From: Nina Sidhu
Sent: 10 December 2018 16:41
To: Anita Gardner
Subject: RE: FIG/159/18/PL Bluebird Cafe

01  
2002  
PROPOSED GROUND FLOOR PLAN  
Scale: 1:100

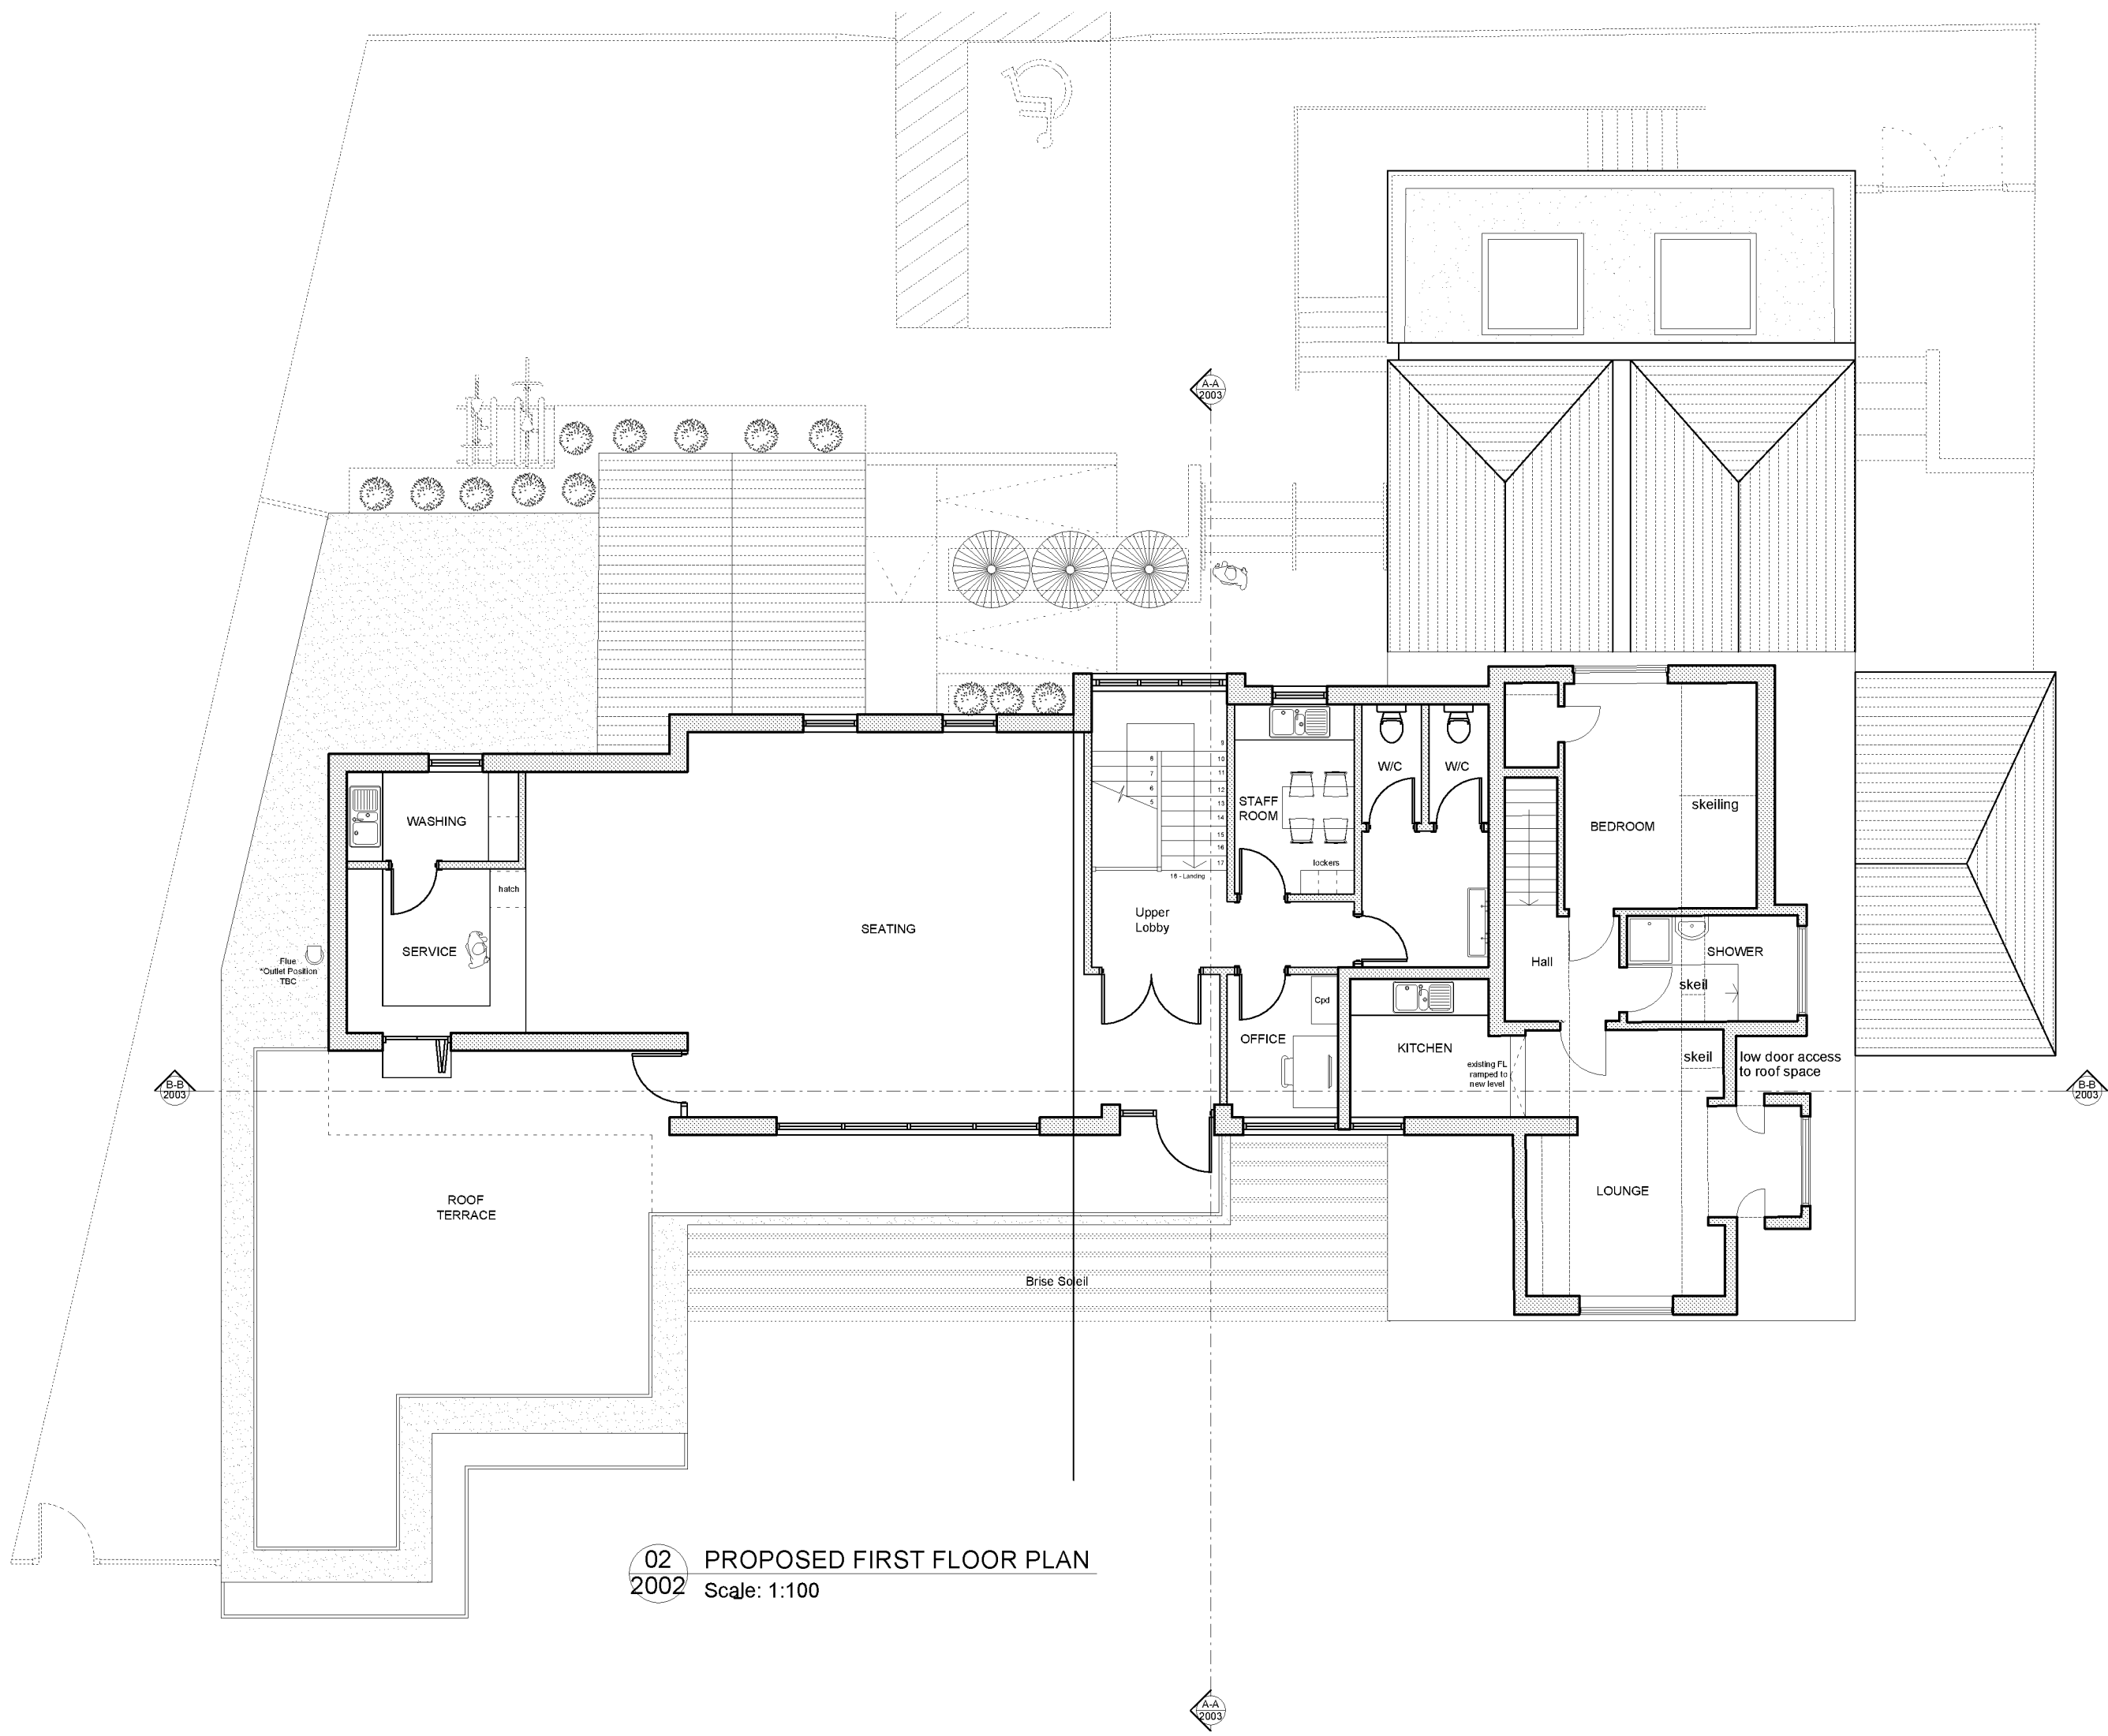
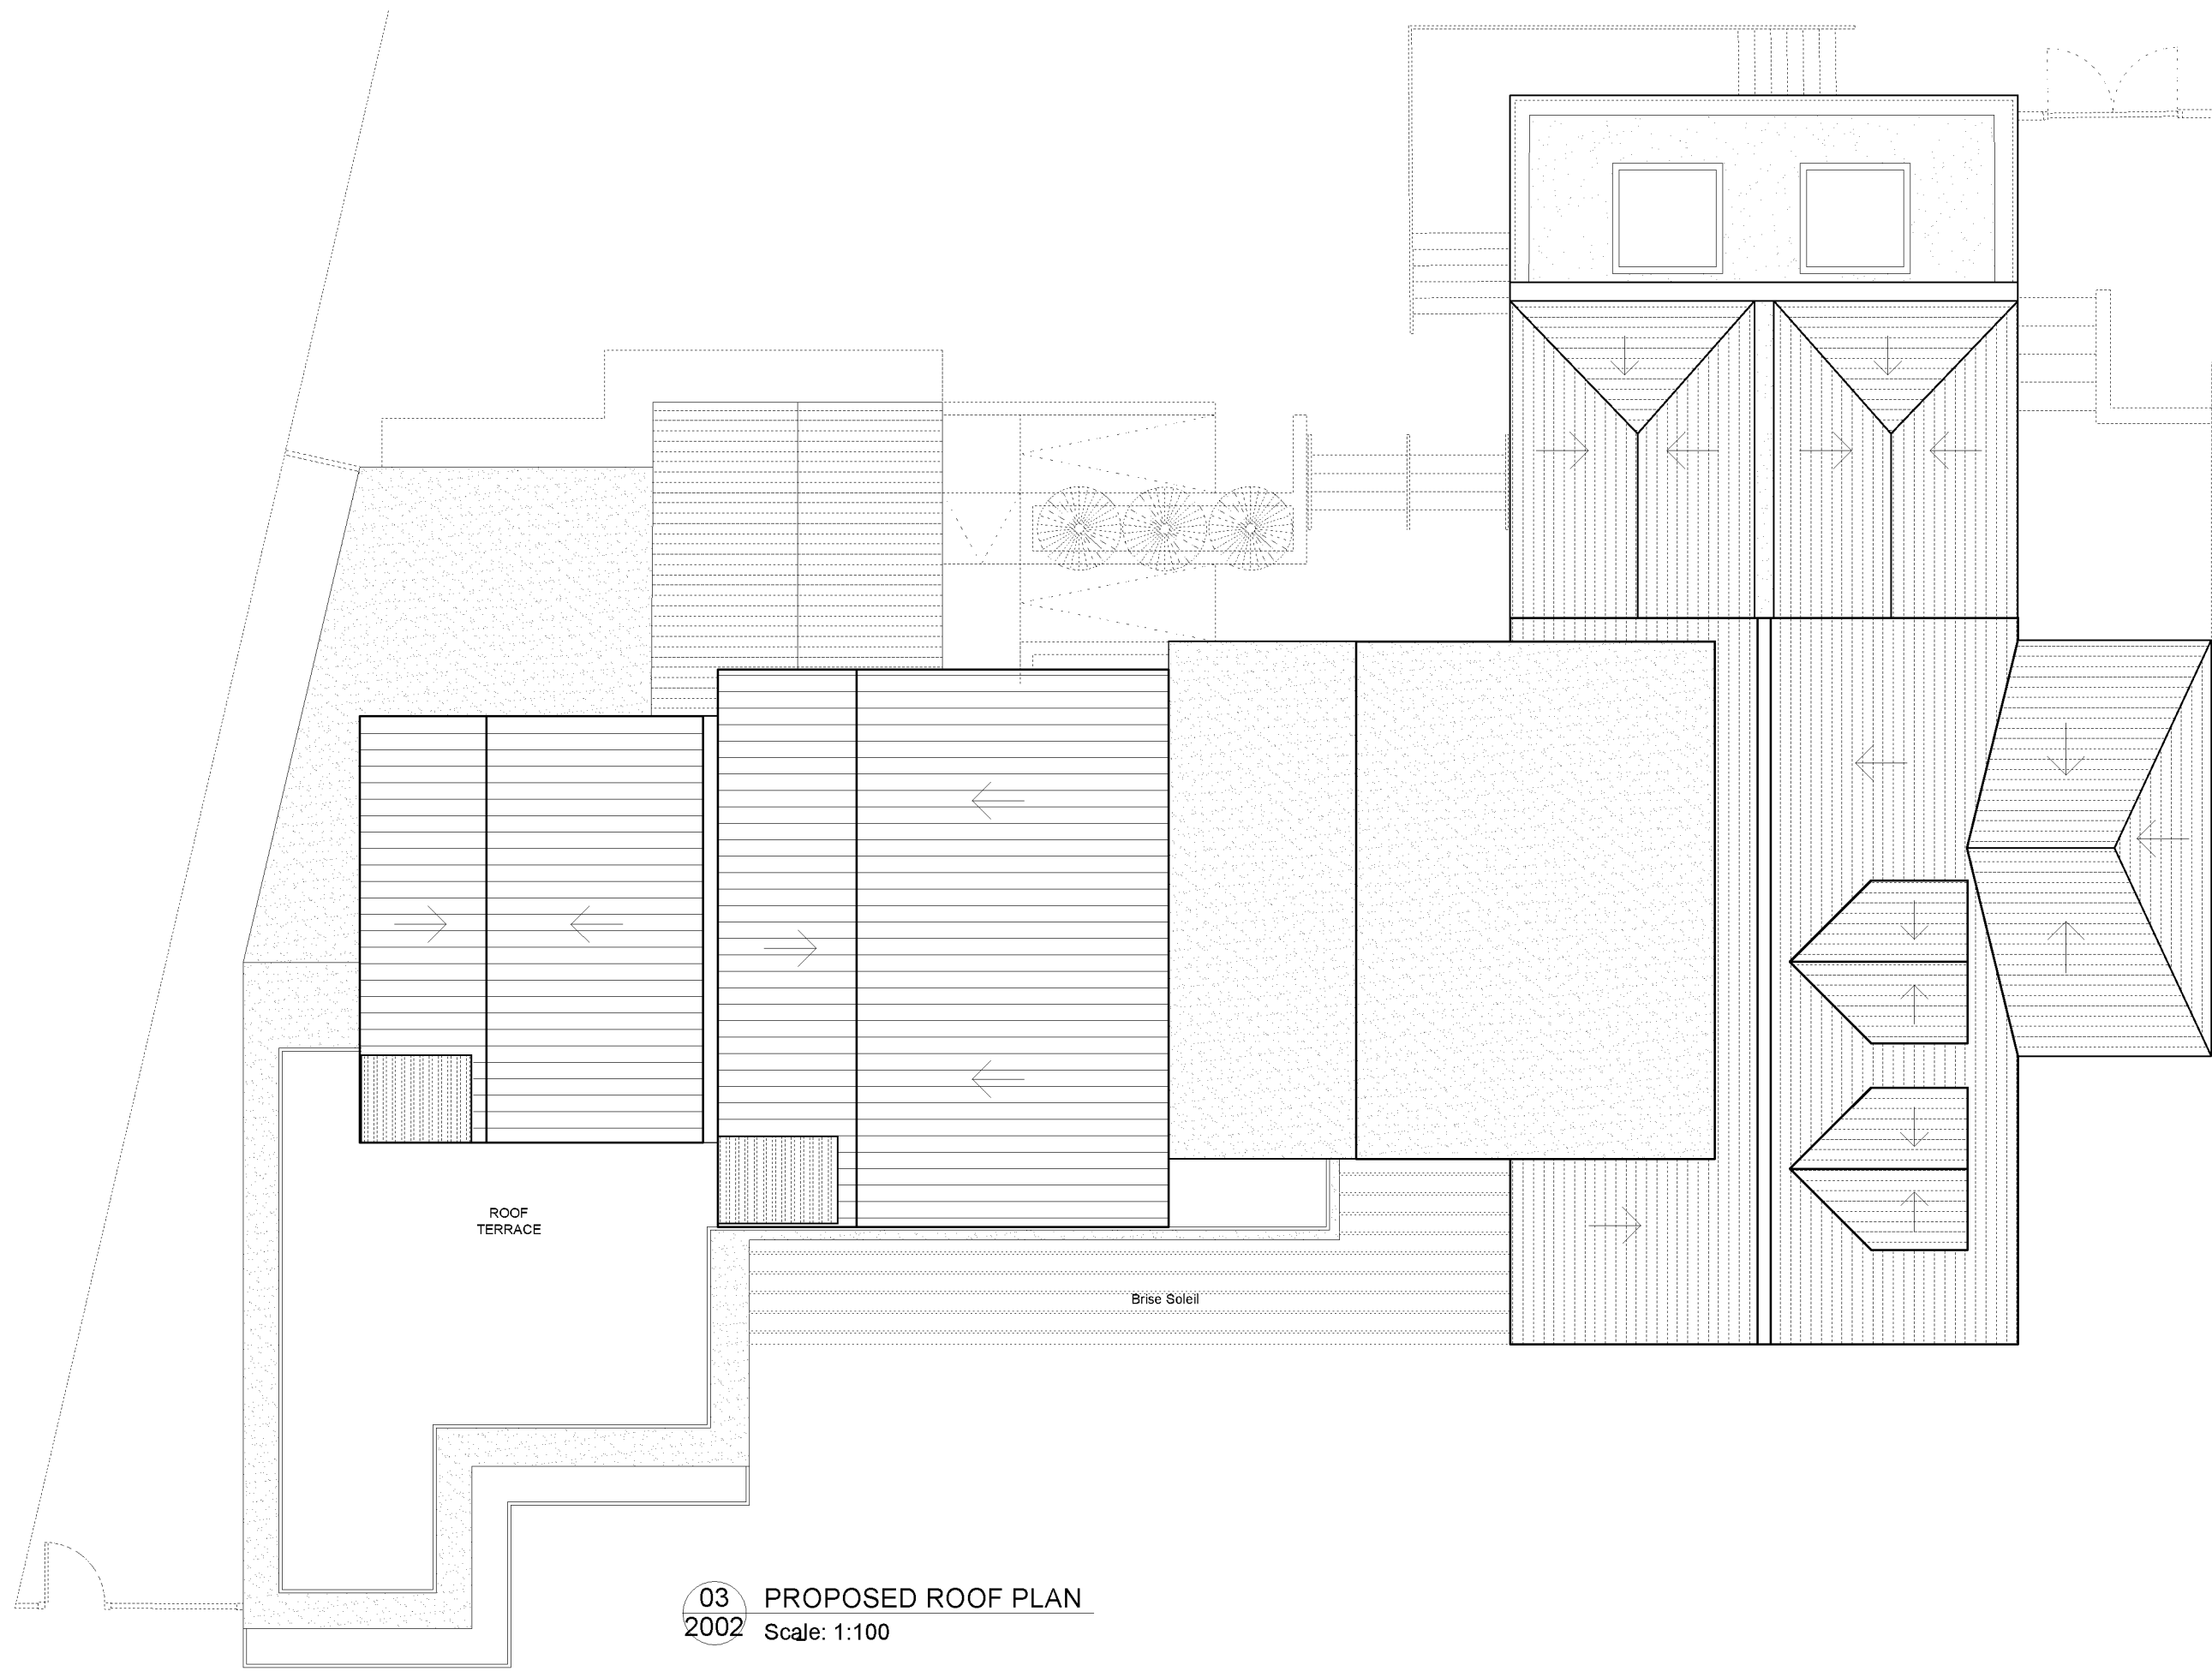
From the revised plan I calculate on the basis that the toilet provision on the first floor is for staff only, that the toilet provision for customers is satisfactory for up to 200 covers based on an equal male to female split. Covers should therefore not exceed 200.

1. I am unclear as the exact number of covers proposed. Is the total number of covers 235? There is slightly conflicting information in the application documents and I would just like to clarify the exact numbers.

2. Sanitary provision: If the total number of covers is 235 the sanitary provision is insufficient and staff do not appear to have been considered. Please refer to Arun's Sanitary Provision Requirements document:
<https://www.arun.gov.uk/download.cfm?doc=docm93jijm4n11783.pdf&ver=11779>

In relation to the comments from the EHO, I herewith provide you with a copy of an amended layout plan with revised WC provision.

With regard to the number of covers, the submitted drawings show a total of 216 as proposed (80 external + 136 internal). This is illustrated on the diagram within the DAS.
